The Planning Inspectorate
Yr Arolygiaeth Gynllunio

Acceptance of Applications Checklist

Fenwick Solar Farm Section 55 Acceptance of Applications Checklist

Non-Statutory Nature Conservation Sites Plan (Document 2.6)

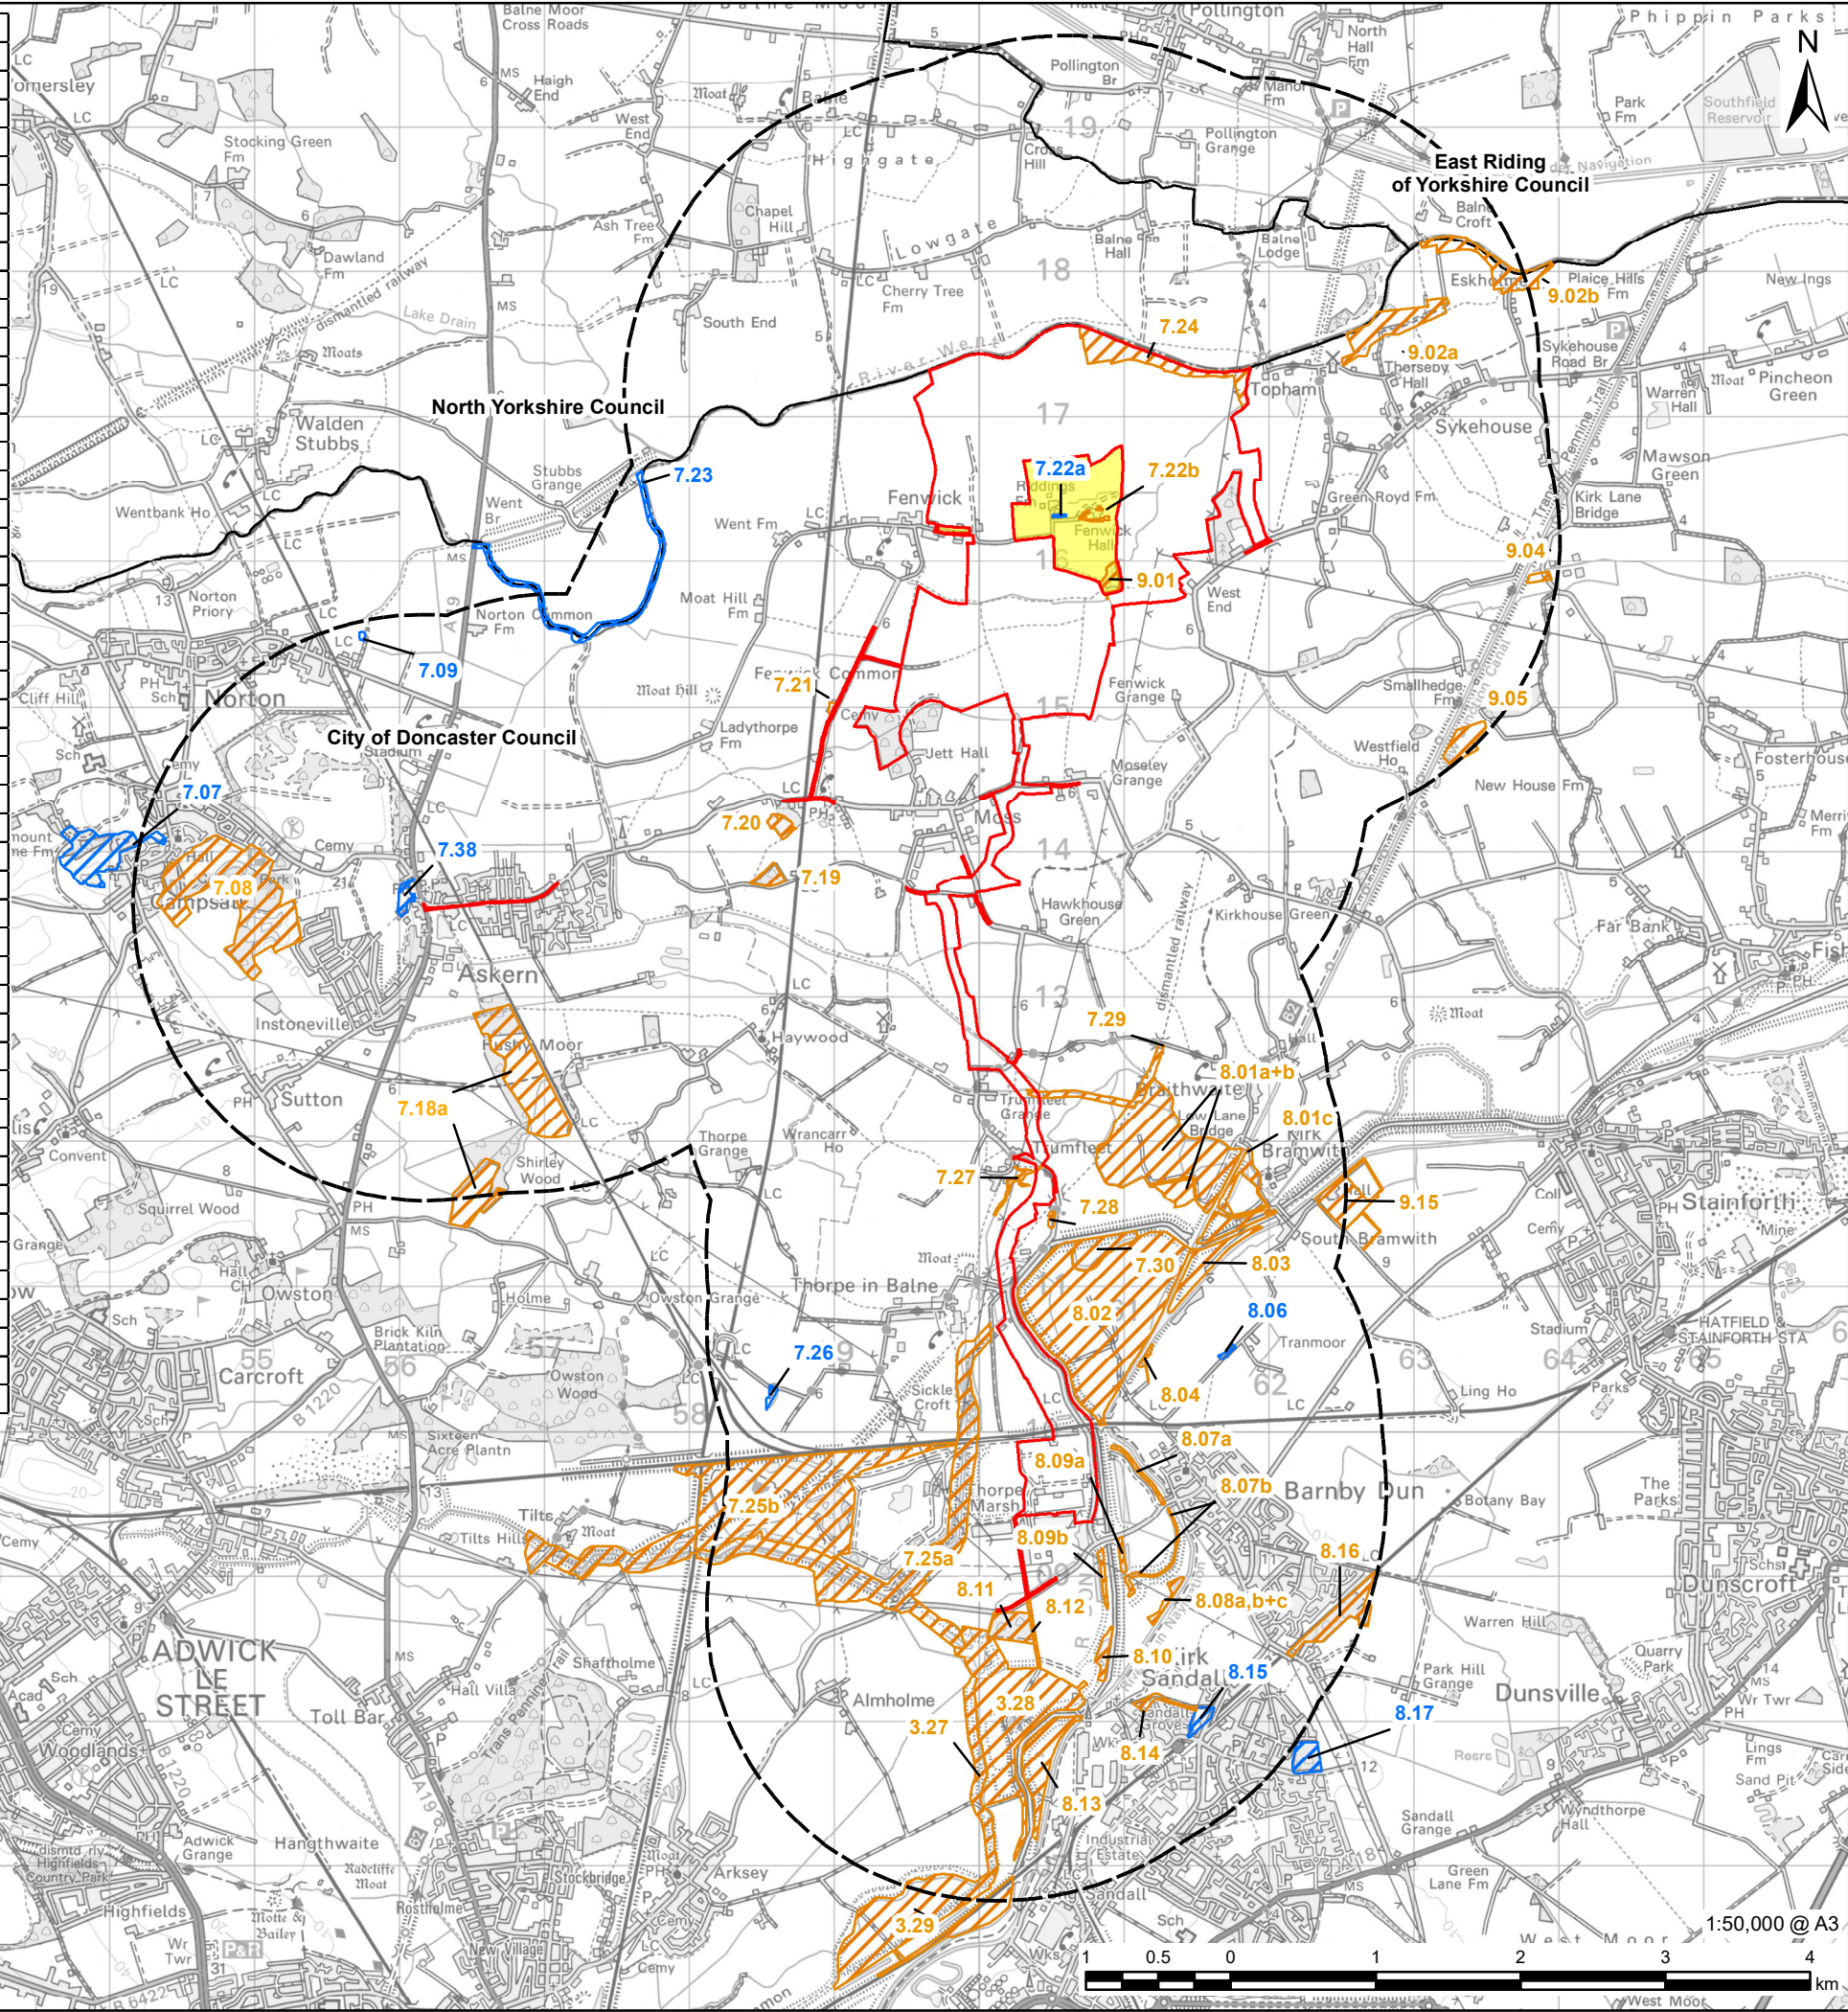
The Non Statutory Nature Conservation Sites Plan does not provide any labelling with the names of the features represented. However the equivalent ES figures do label the features represented. The Applicant is advised to provide an updated plan with appropriate labelling.
